26 February 2018

RE: MODIFICATION OF WHITE ROCK WIND FARM PROJECT (10_0160)

I refer the application to further modify the White Rock Wind Farm Project (10_0160), located 20 km west of Glen Innes in the Glen Innes Severn Local Government Area. Council notes the proposed modification, submitted by White Rock Wind Farm Pty Ltd involving:

Figure 6.3 WRWF Stage 1 and 2 predicted operational noise level contours

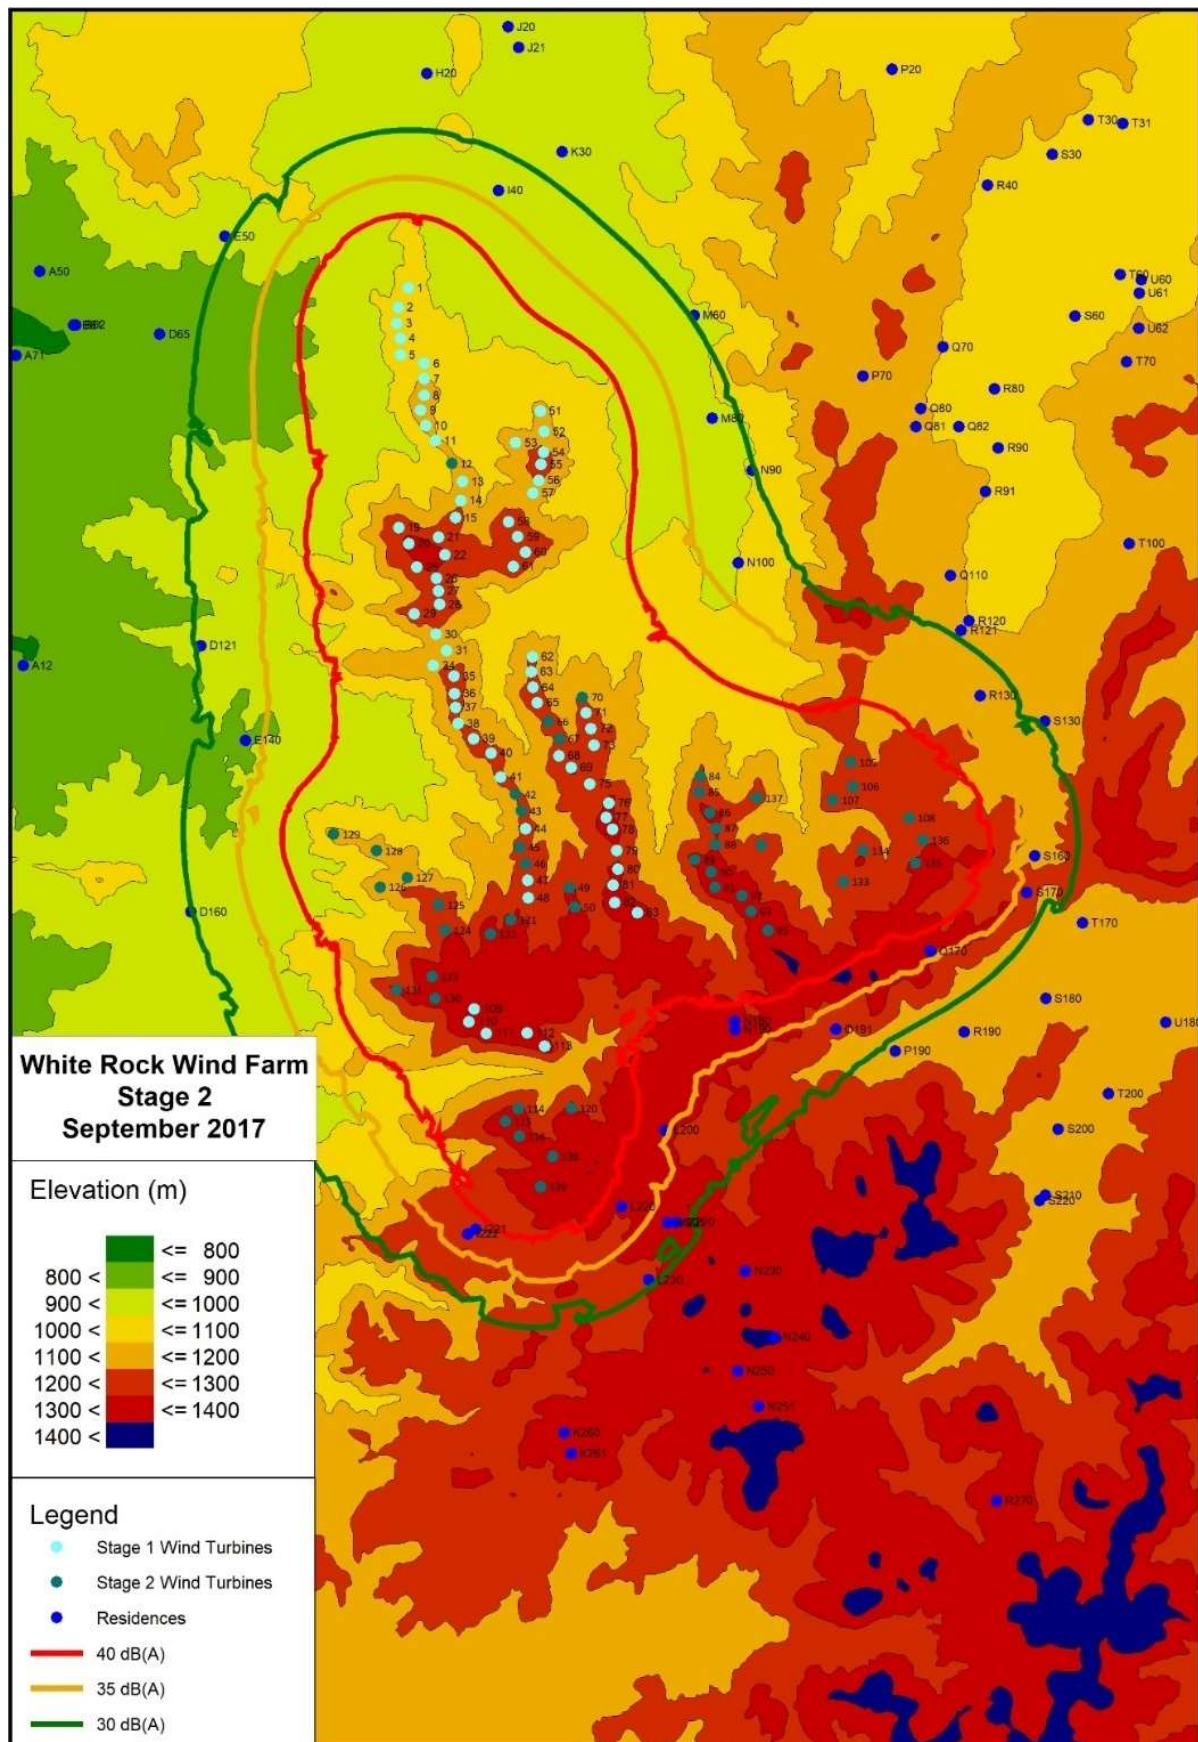
3. In view of the increase in size it is recommended that the Proponent prepare a Noise Compliance Report which assesses the performance of the project against the operational noise criteria as specified in the environmental assessment.

4. In the event that the Noise Compliance Plan indicates that noise from the wind turbines exceeds the noise limits specified under the environmental assessment, as relevant, the Proponent shall investigate and propose mitigation and management measures to achieve compliance with the noise limits.

Figure 6.6 Transport access routes for Stage 2

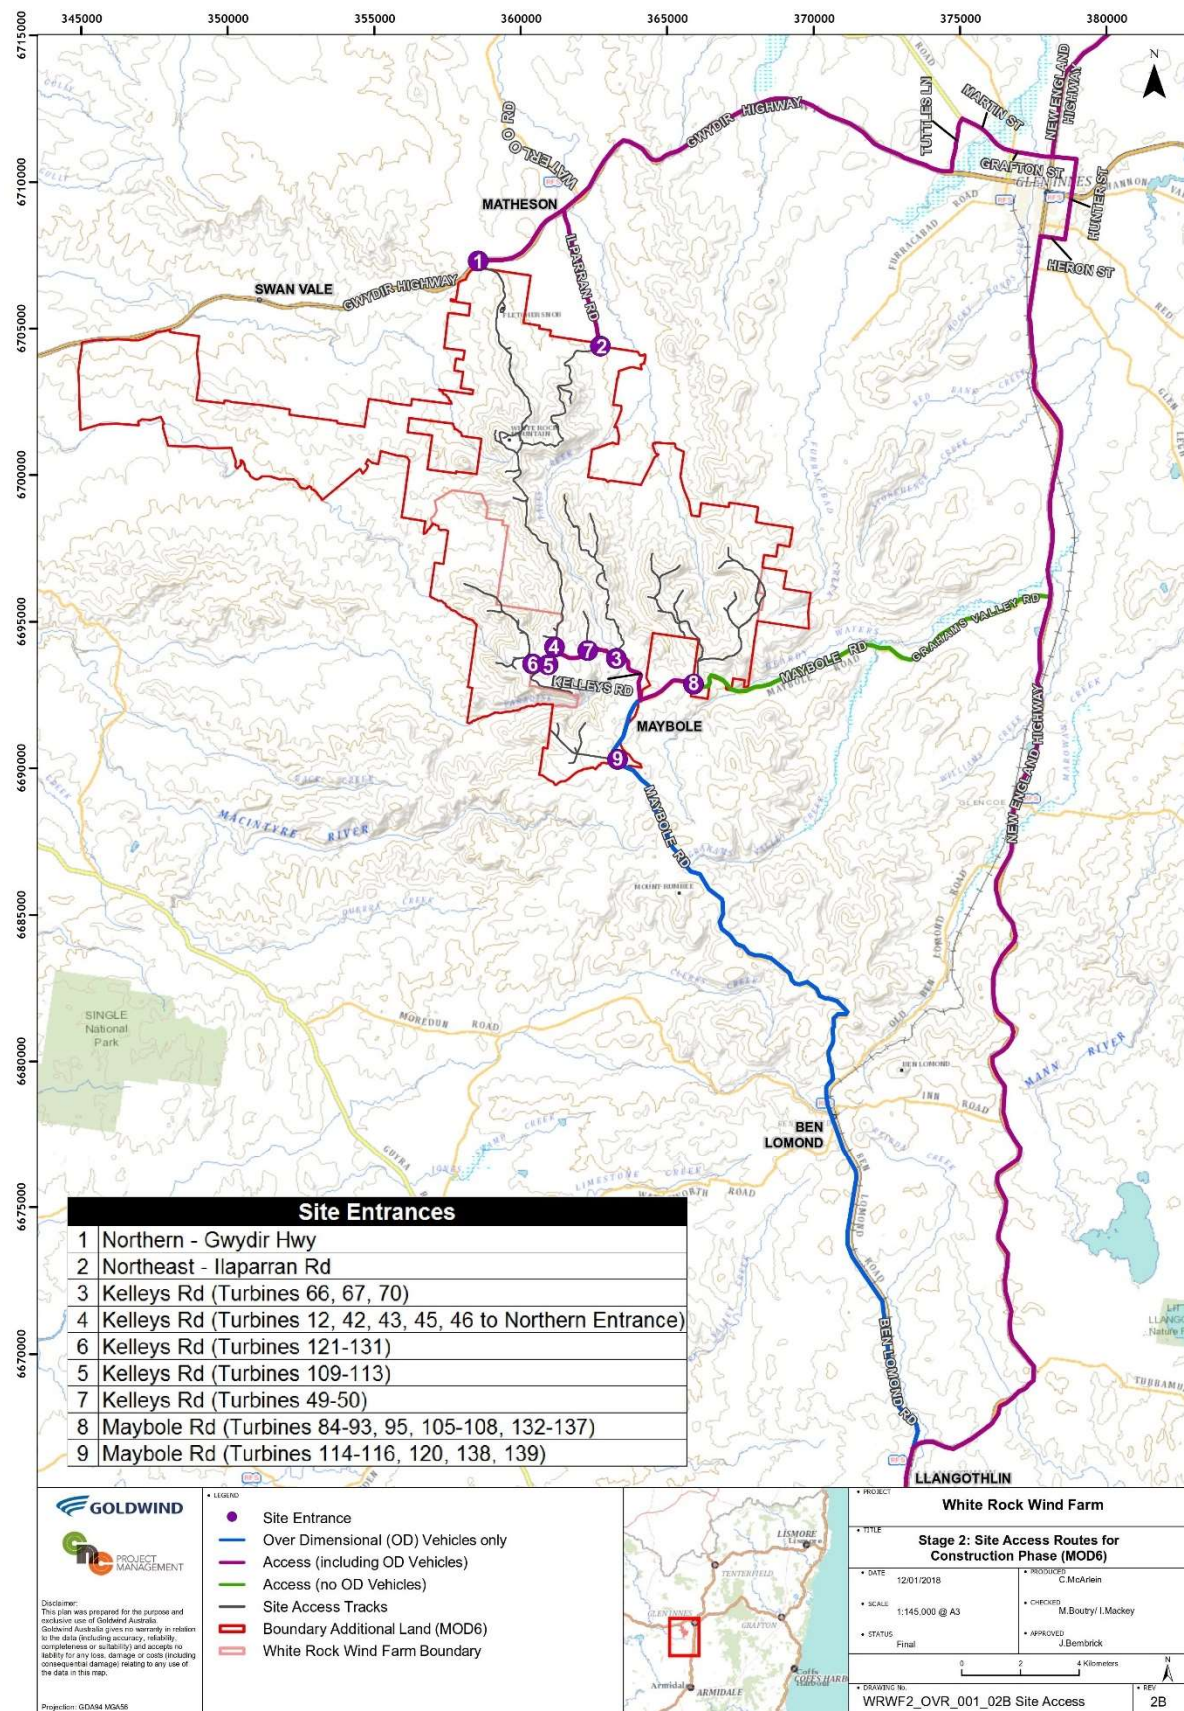
5. It appears that the EIS has not included any analysis of traffic or transport impact. A full analysis of the impact on haulage routes should be undertaken. This should incorporate an assessment of the impact that was actually incurred in Stage 1,

and whether the dilapidation agreement that was in place for stage 1 adequately captured the impacts on the network. This should be completed by the same contractor that performed the dilapidation surveys for stage 1, and all information collected with regard to road dilapidation should be made available publicly.
